Ref: 6/2023/2418/OUTLINE
Date: 12/01/2024

HISTORIC BUILDINGS AND CONSERVATION ADVICE

RE: Former Hook Estate and Kennels, Coopers Lane Road /Firs Wood Close, Northaw EN6 4BY

This application is an outline planning application with all matters reserved except for primary means of access for C2 (extra care) dwellings, ancillary community facilities, landscaping, and access from Coopers Lane Road.

Project.	Northaw.
Client.	Swing Limited.
Date.	06.09.23.
Drawing No.	SK01. Rev. R9
Author.	RCJ Scale. 1:1250 @A1.

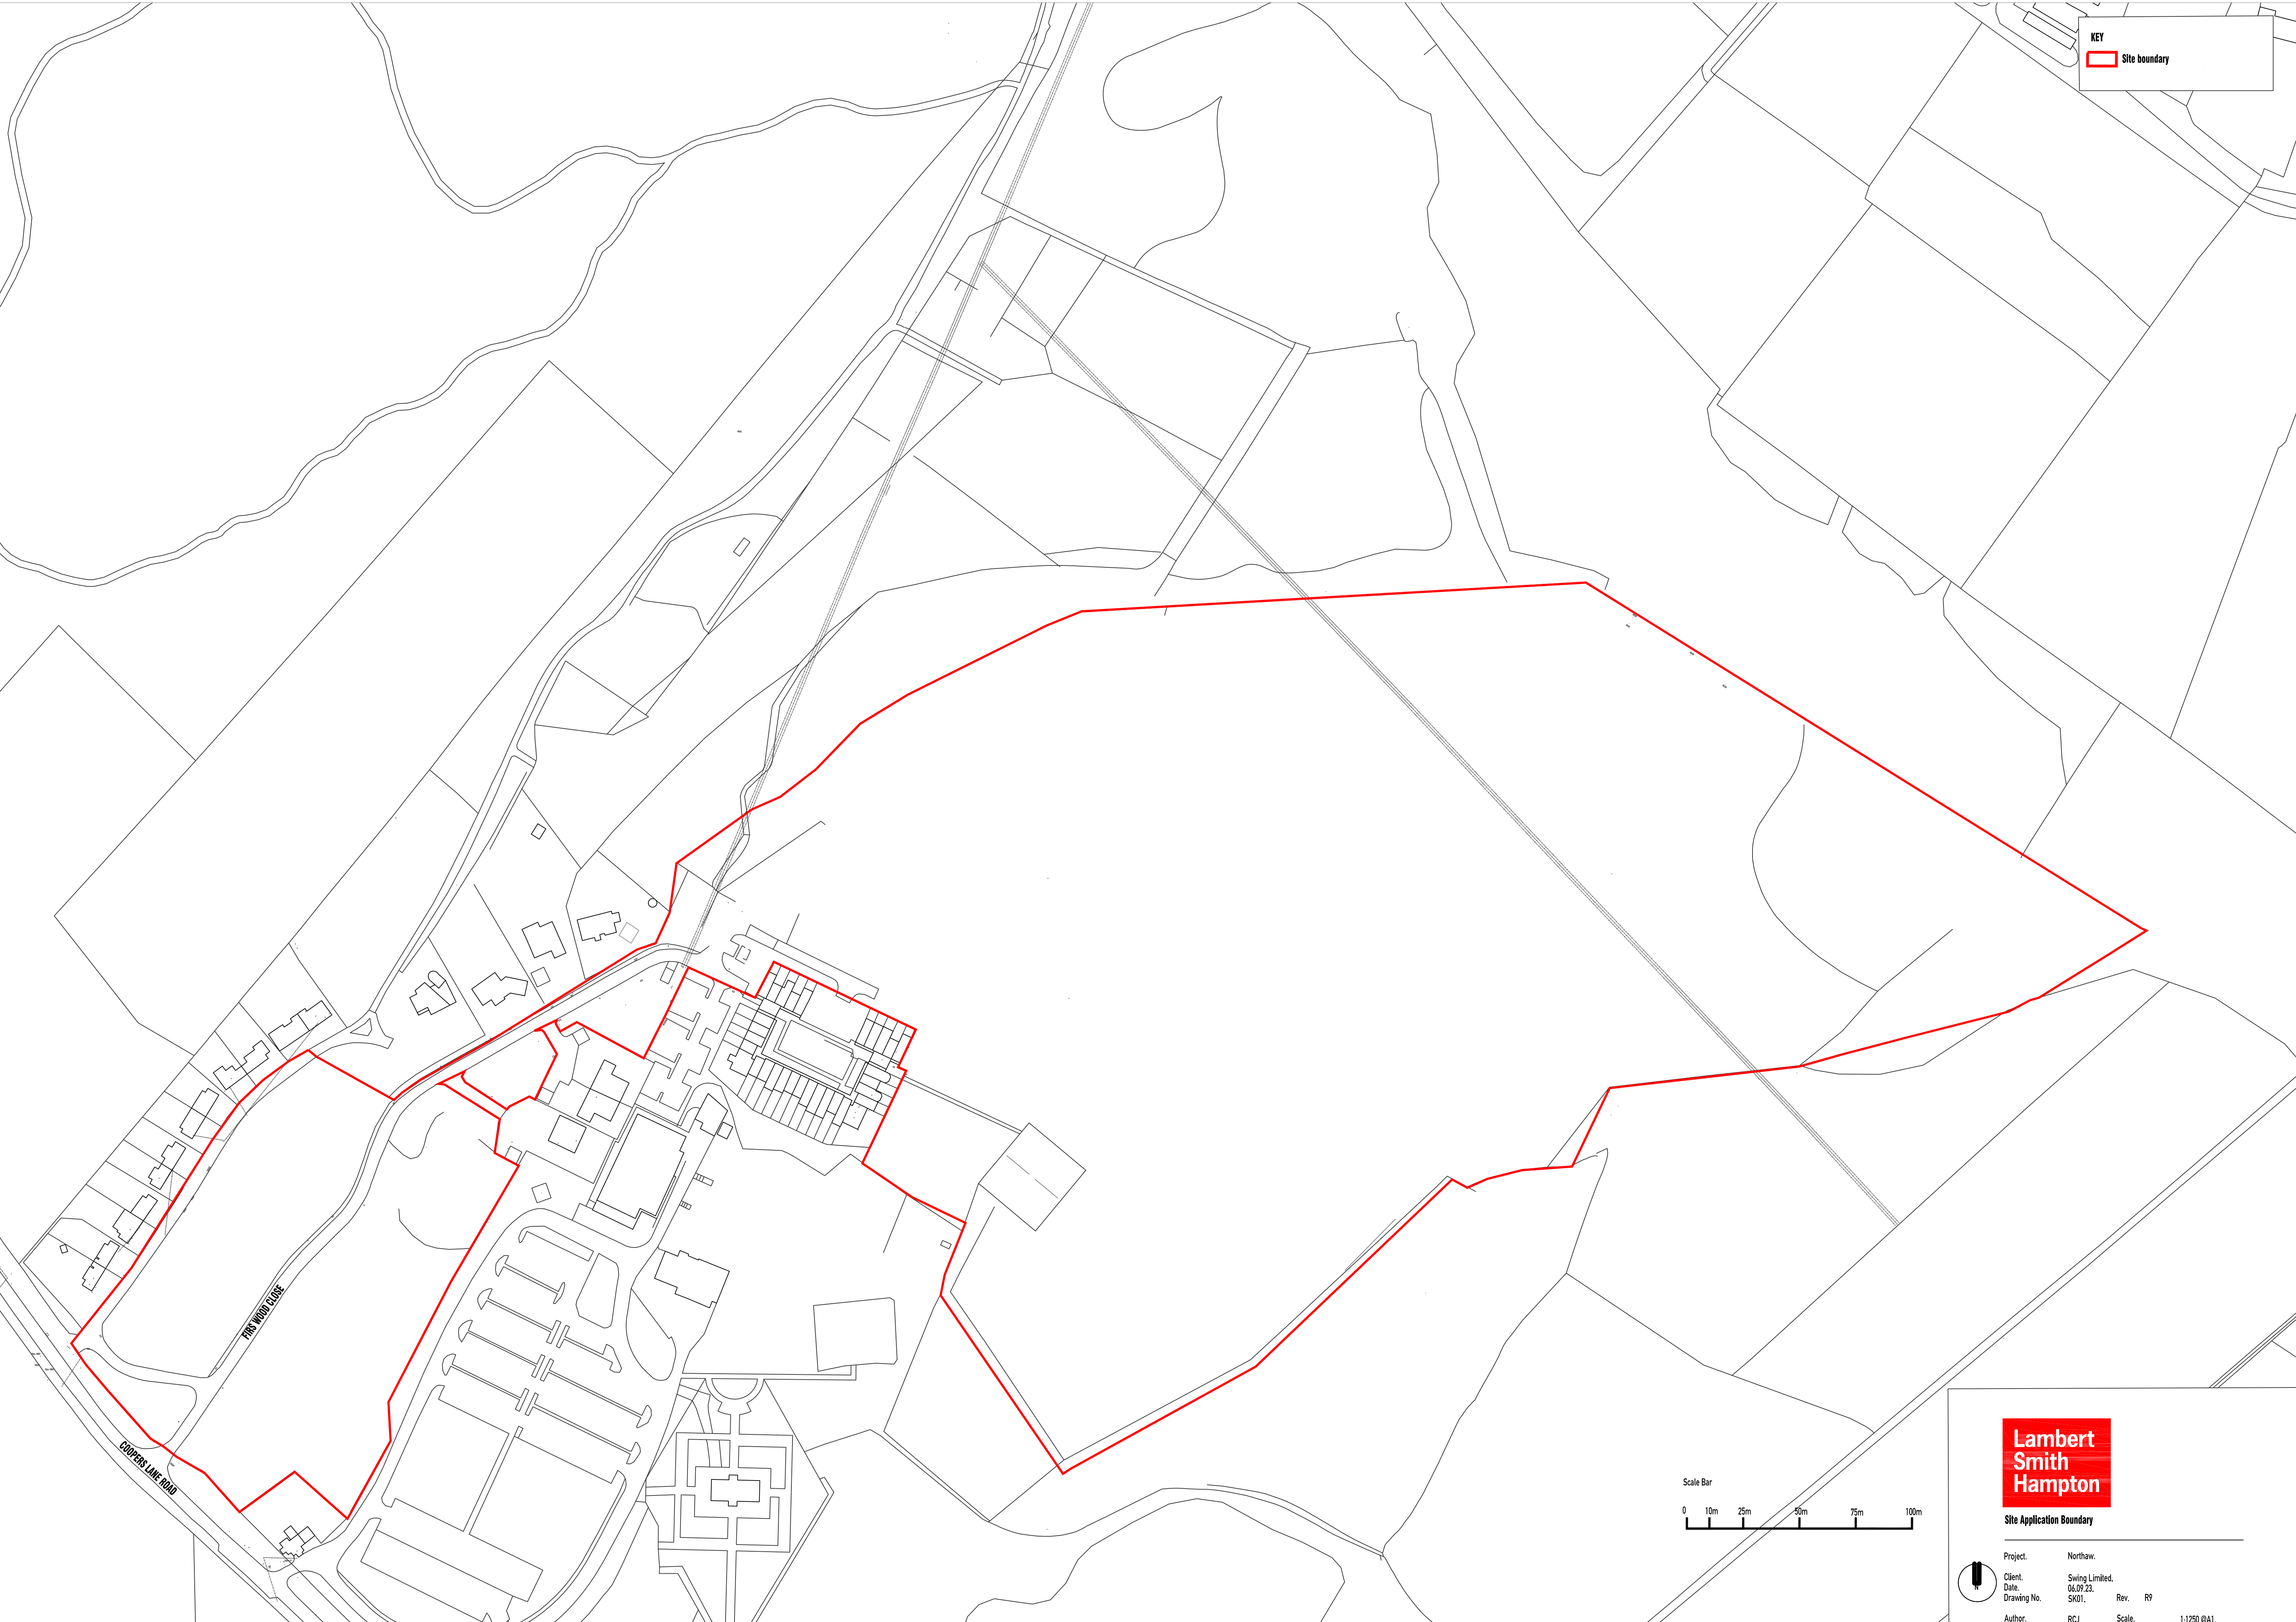
The proposal would remove one of the remaining views from the listed building out towards a rural landscape and conversely back towards the listed building which has been found to contribute positively towards significance. The proposal would result in a fundamental alteration to the landscape character of the application site from an undeveloped, heavily treed site to an urbanised residential development. This change cannot be considered to have a beneficial or neutral impact on the listed building as it results in the loss of a positive element of its setting.

The proposal would result in the listed building being almost surrounded by modern development, divorcing the listed building from the wider rural landscape. Pre-application advice stated that the east of the house should remain undeveloped, and the current scheme has not adopted this advice. I acknowledge that the buildings closer to the listed building would be one storey in height which would go some way to reducing the visual impact, but there remain concerns about the extent of development proposed. The existing development does not set precedent for further harmful changes; the proposal would encroach modern development further into the rural landscape which would have a cumulative negative impact on the significance of the listed building (as per page 4 of Historic England's *The Setting of Heritage Assets*).

Planting could not mitigate the harm completely due to the fundamental change to land use and landscape character. There would be wider environmental changes as a result of the proposed development which could not be mitigated by new tree planting. In any case, it is likely that existing trees would need to be removed to accommodate the proposed development and the managed character of the planting on the illustrative masterplan would be vastly different to the more naturalistic character that exists today.
